REF: BURGER KING LOMAS (J14-D57)

A preliminary review of your submittal for building permit approval has shown that the following information is lacking for this section to begin the review process:

RE: DRAINAGE PLAN FOR BURGER KING @ LOMAS  
RECEIVED NOVEMBER 5, 1985 (J-14/D57)

J14/D57

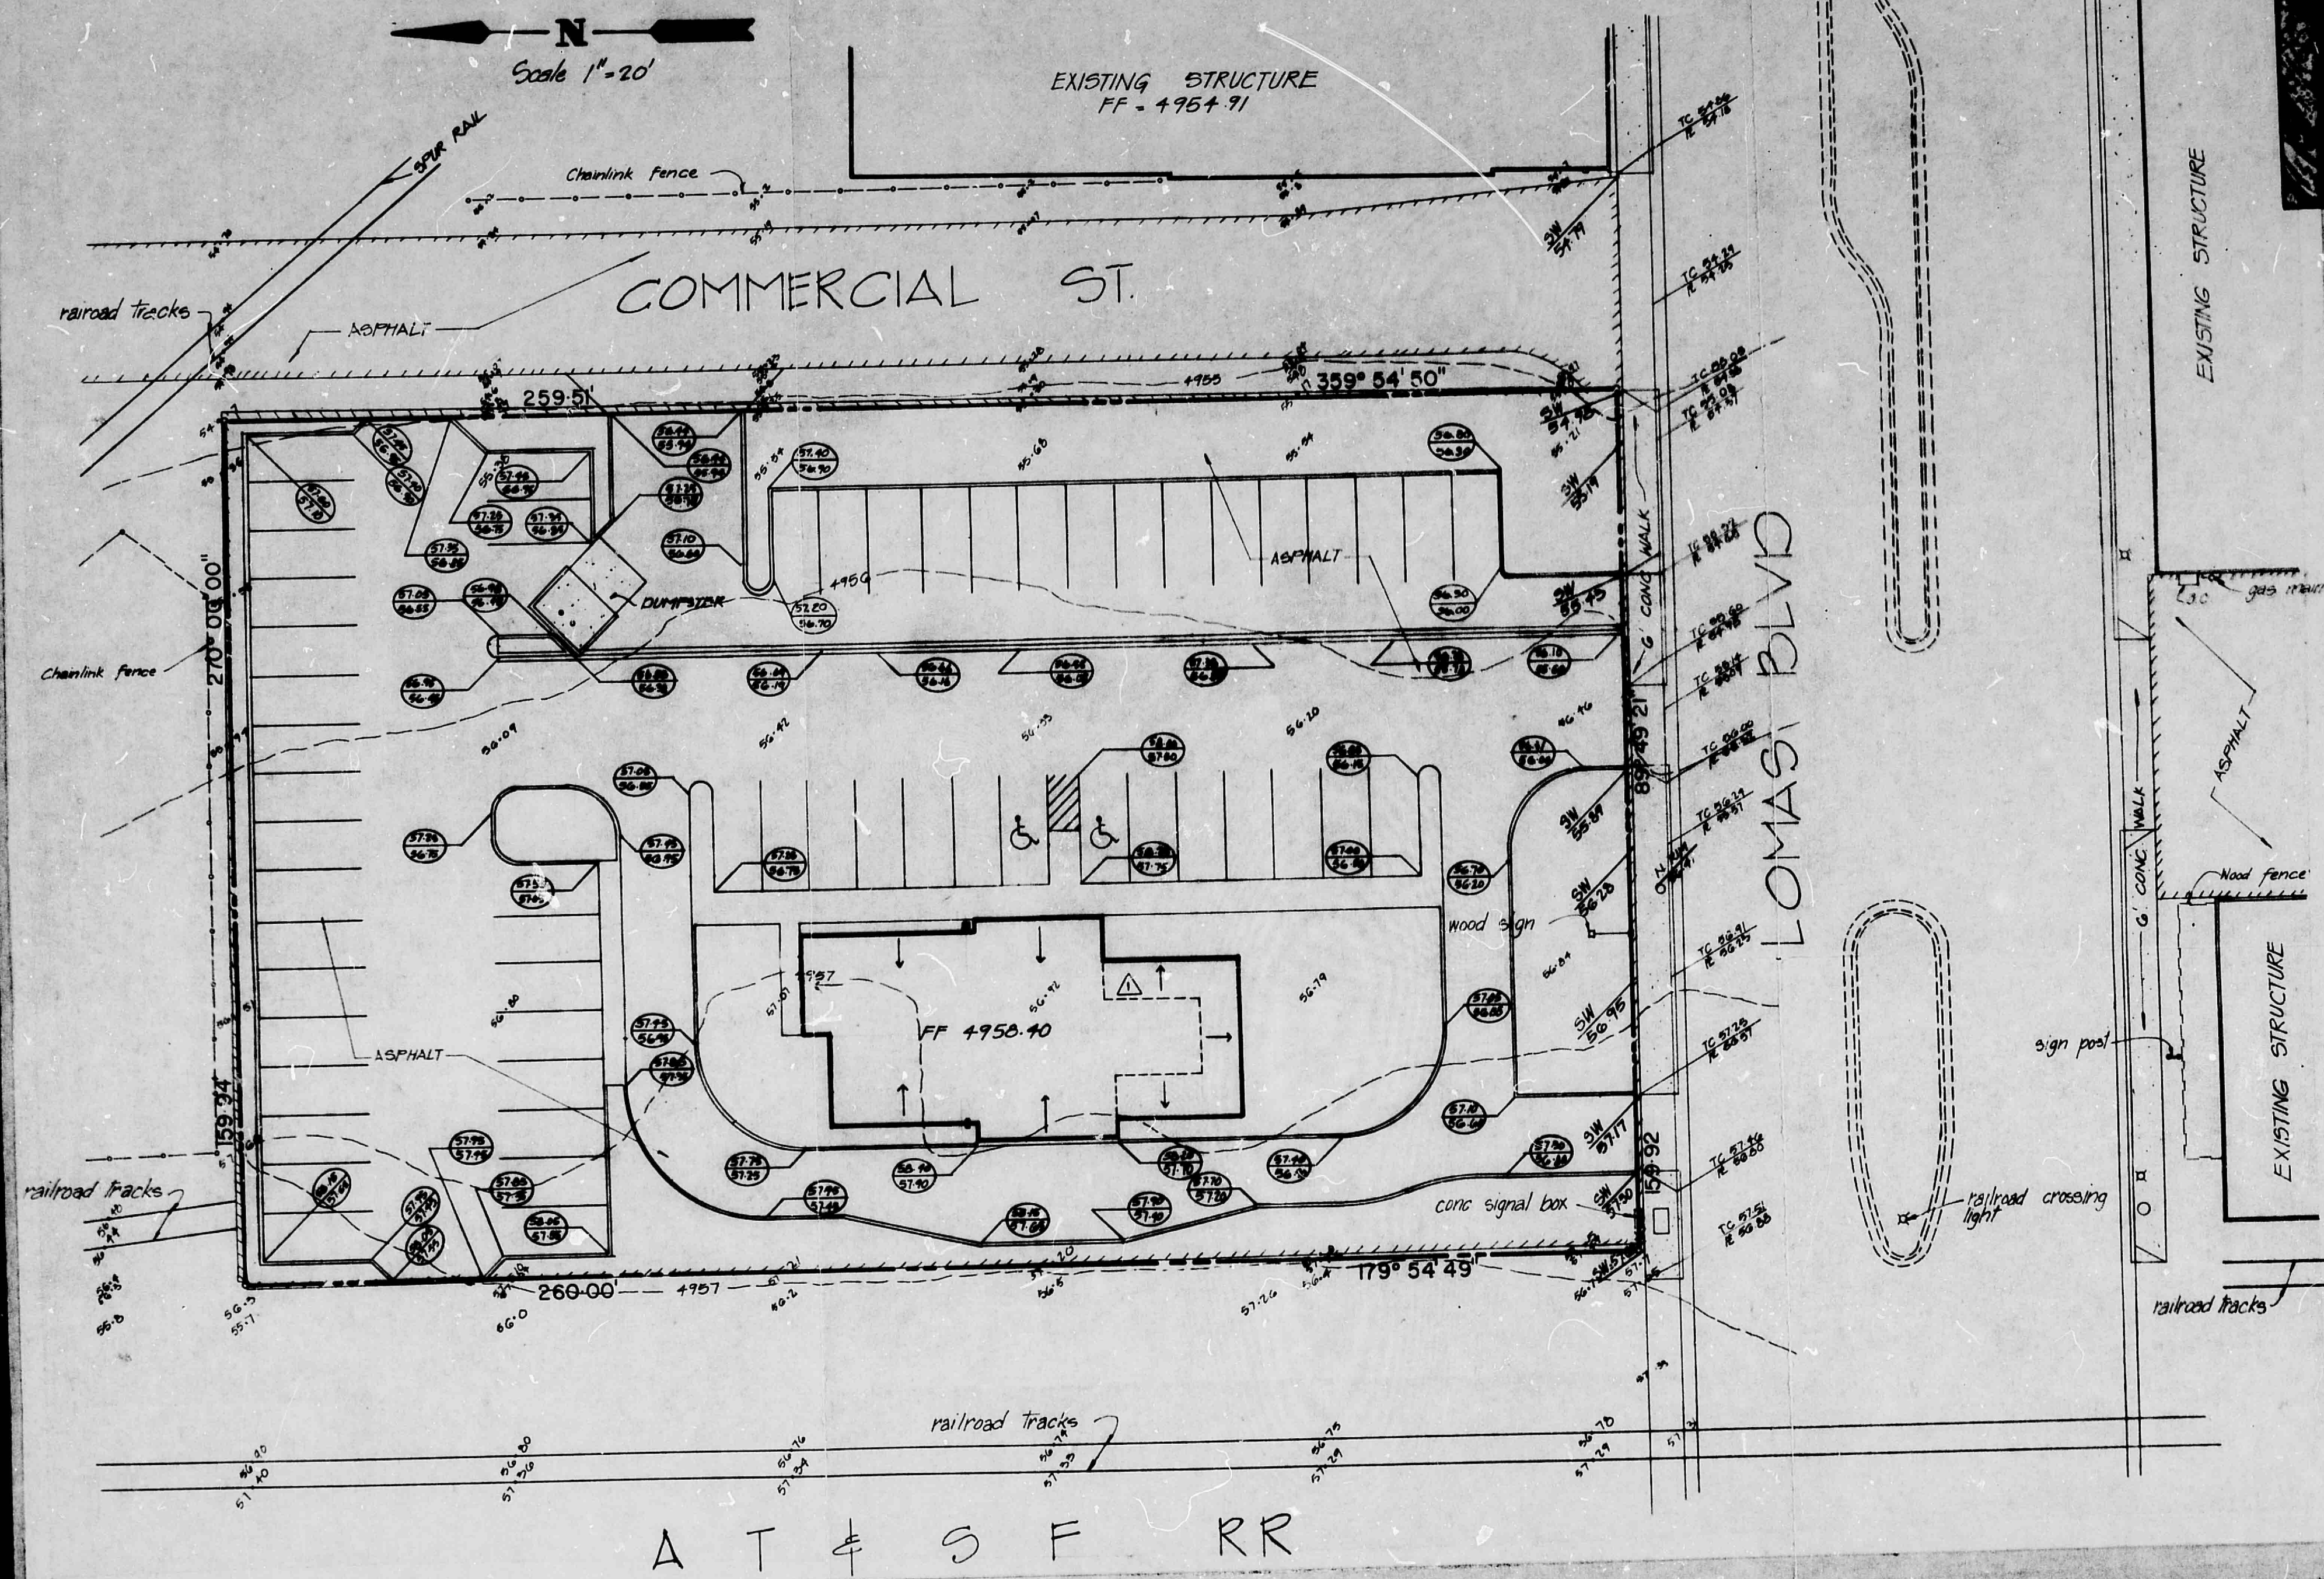
Plan Drawing:

1. Bench Mark description/location.
2. TBM location.
3. Location and/or direction of flow for roof-drains.
4. Please include a legend.
